**DEVELOPMENT REVIEW BOARD  
ACTION SHEET**

DRB- 1006904                      Item No. 16                      Zone Atlas D-18

SUBJECT: Project # 1006904, 07DRB-70320 Sketch Plat Review and Comment, North Albuquerque Acres, Tract A, Unit A, Lot 17, Block 5, Located on San Francisco Dr. NE Between San Pedro Dr. NE and I-40 Frontage Rd.

**RE: Lot 17, Block 5, N.A.A. Tract A, Unit A/sketch**

SKETCH PLAT OF
LOTS 17-A & 17-B
BLOCK 5
TRACT A, UNIT A
NORTH ALBUQUERQUE ACRES

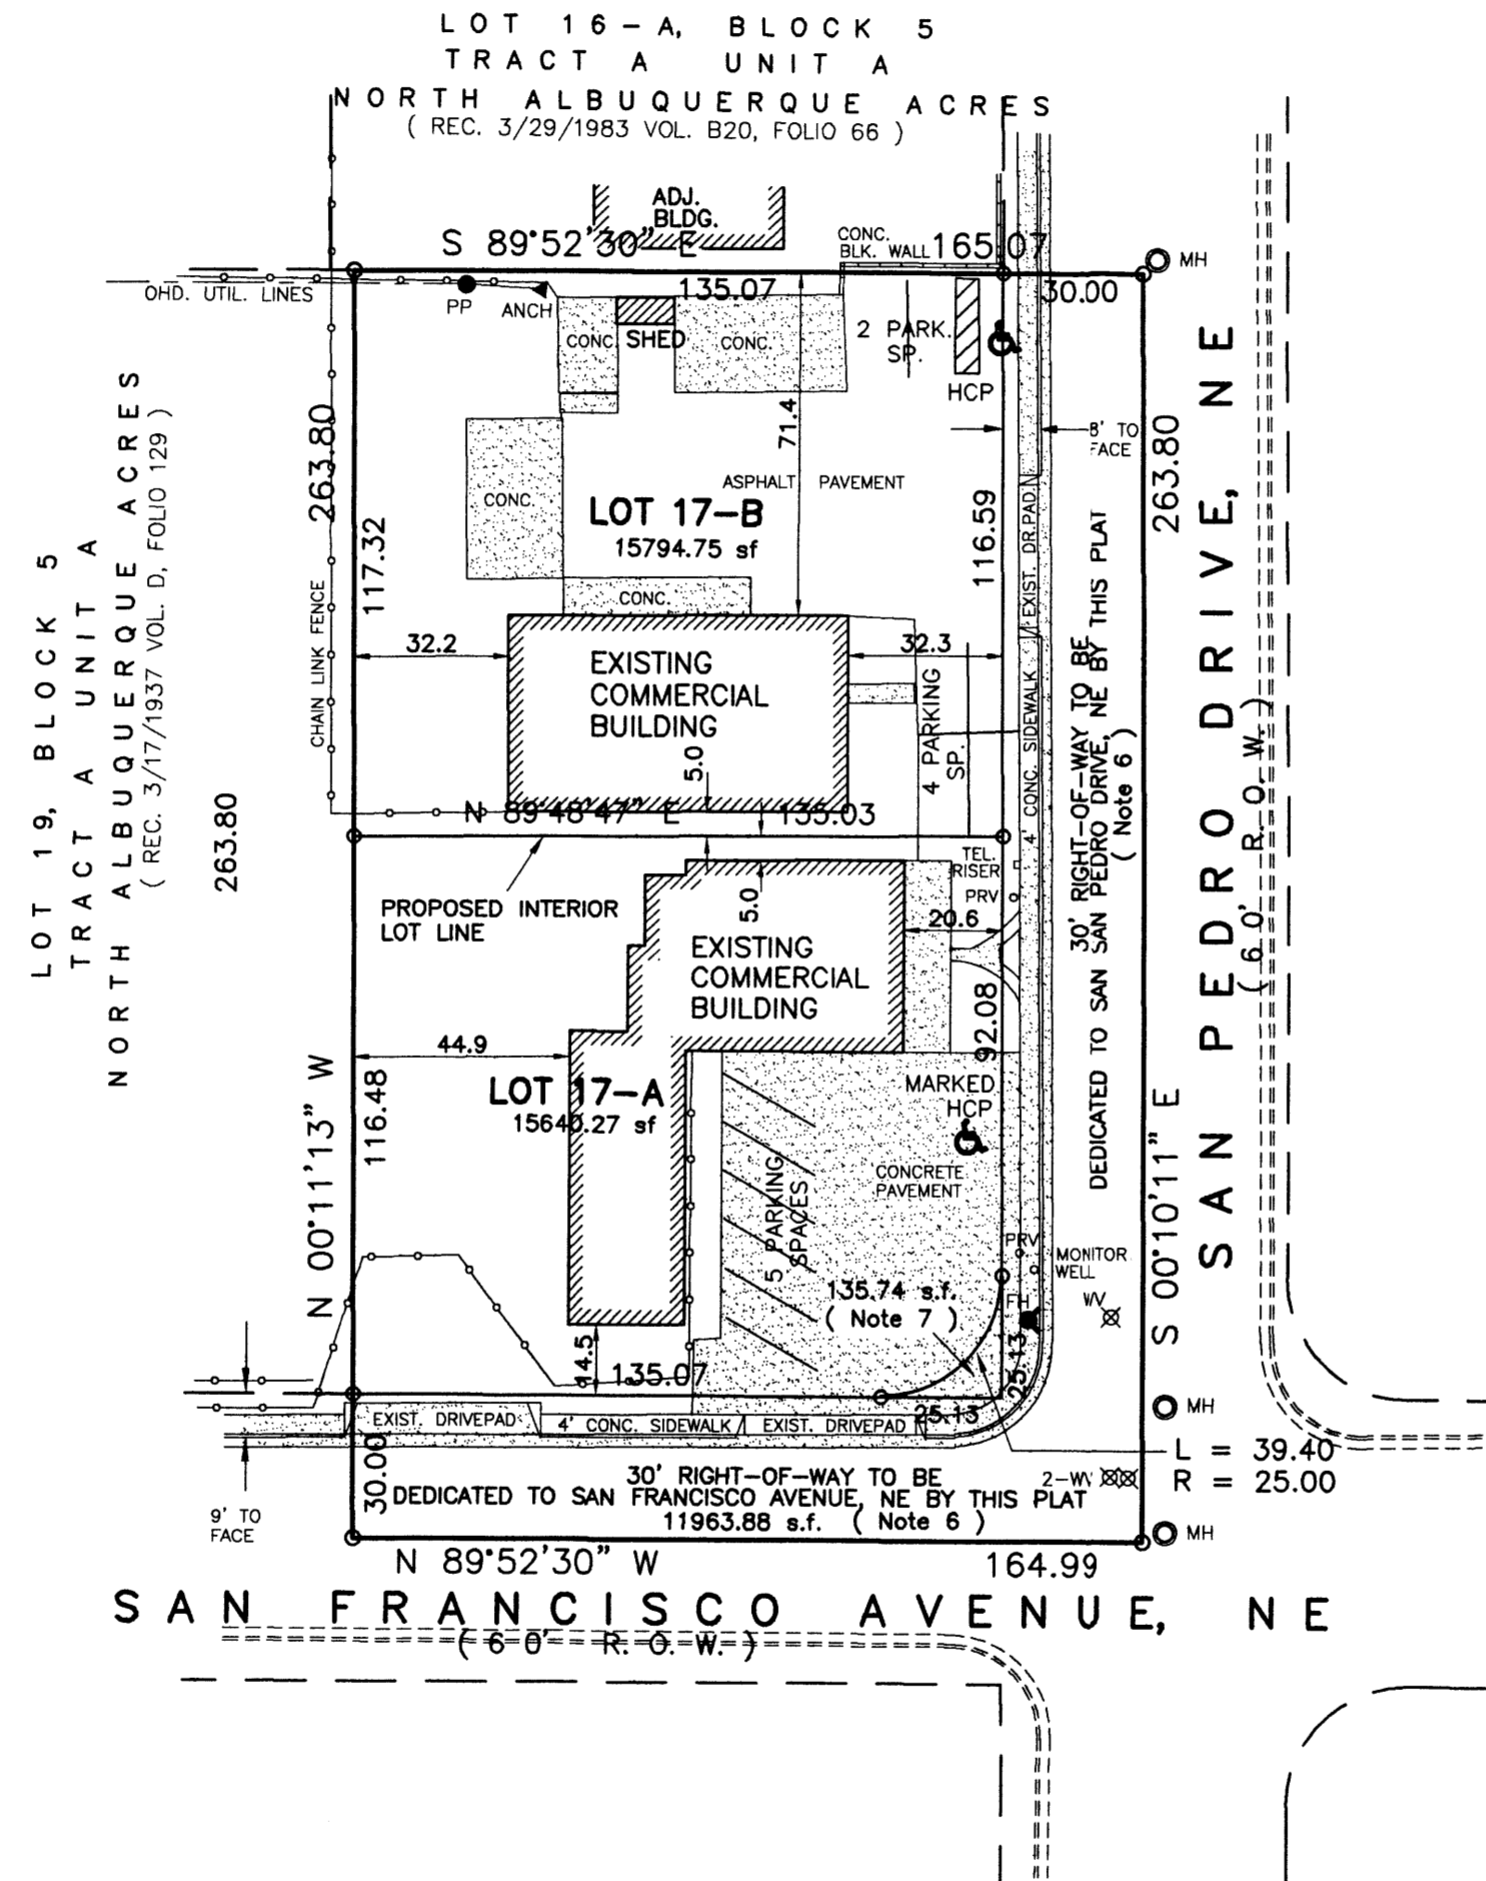
- 1) San Pedro is classified as a collector and may require dedication.
- 2) A parking analysis is needed for each proposed lot.
- 3) Is there cross access between the lots?

There is the potential for above-named project to be impacted by the presence of landfill gas generated by a former City owned/operated landfill (San Francisco Landfill). It is acknowledged that this agenda item is for a Minor-Sketch Plat or Plan; however, if development/redevelopment does occur, the developer of this site is required to follow the most current version of the "City of Albuquerque Interim Guidelines for Development within City Designated Landfill Buffer Zones." A review and approval of the Site Plan(s), the proposed construction, design drawings, and a certification of construction will be required by the Environmental Health Department, Environmental Services Division.

The property is located within 1000 feet of a landfill. Please contact Environmental Health for further details.
